# KITTITAS COUNTY FIRE DISTRICT 7

## **Subject: Zoning Variance application: VA-26-00001 Regan Setback**

Regan, Tracy
1011 Sky Meadows Dr., Cle Elum, WA
Parcel ID: 116734
Map #: 19-16-17050-0003

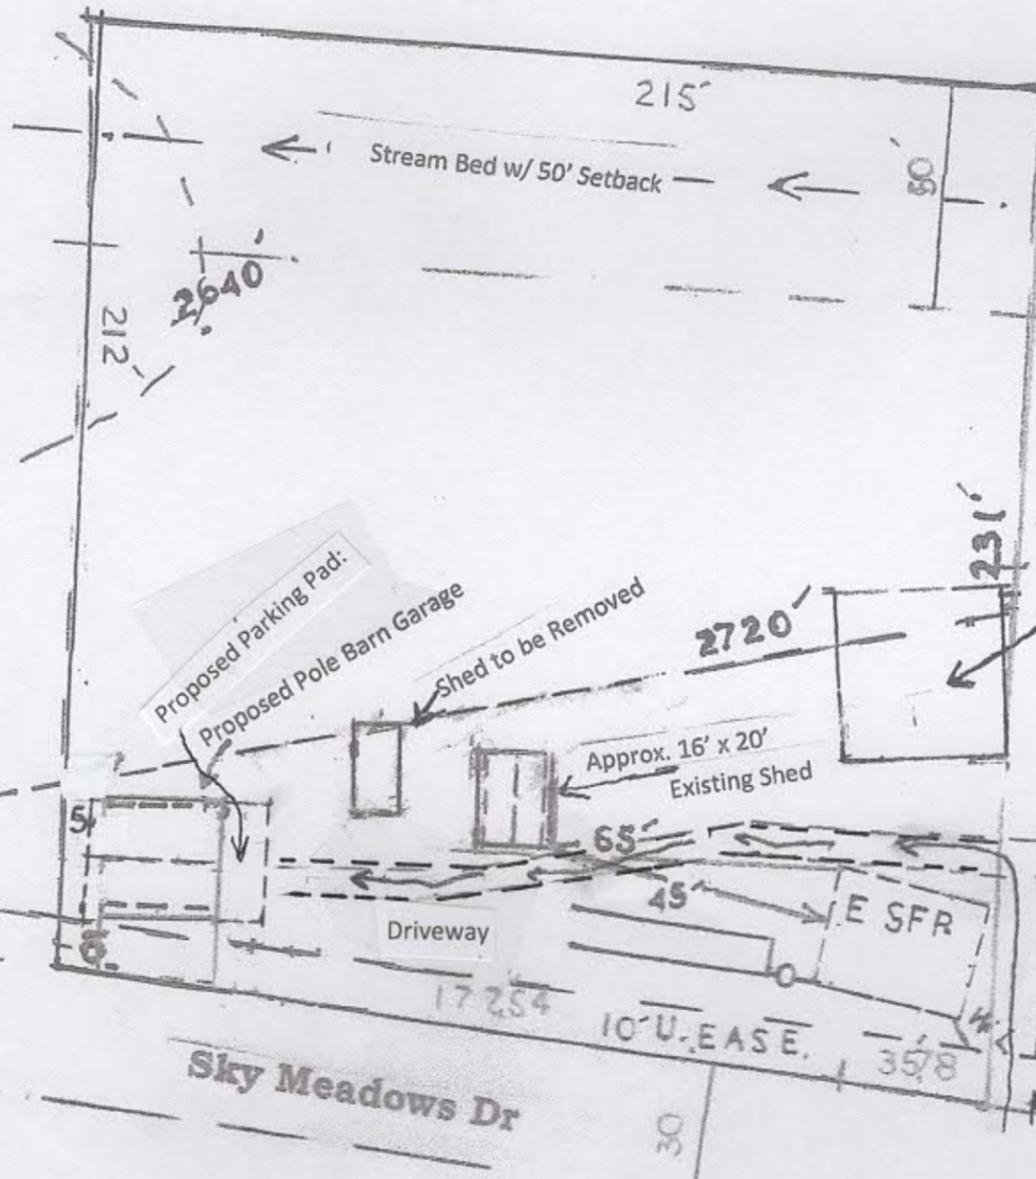
Kittitas County Fire District #7 has reviewed the variance request proposing a reduction from the required 15-foot side lot line setback to 10 feet, and a 15-foot reduction from the required 25-foot front line setback. If approved, this variance would result in a 5-foot side lot setback and a 10-foot front lot setback for the construction of a detached pole barn/garage. After careful consideration, we do not support the approval of this variance due to several public safety concerns.

A 5-foot side setback and a 10-foot front setback significantly decrease the buffer between the proposed structure, the roadway, and the neighboring parcel. This limited space may obstruct access for fire apparatus and other emergency vehicles.

Kittitas County is located within a high-risk wildland-urban interface zone. Structures situated closer to the road may be more susceptible to ignition from roadside fires or windborne embers. Reduced setbacks also limit defensible space, which is essential for protecting structures during wildfire events.

We recognize that the County already requires non-combustible Class A roofing materials. However, if the variance is approved despite the concerns noted above, we strongly recommend requiring additional ignition-resistant construction features, including fire-resistant siding and ember-resistant vents, to help mitigate increased risk associated with reduced setbacks.
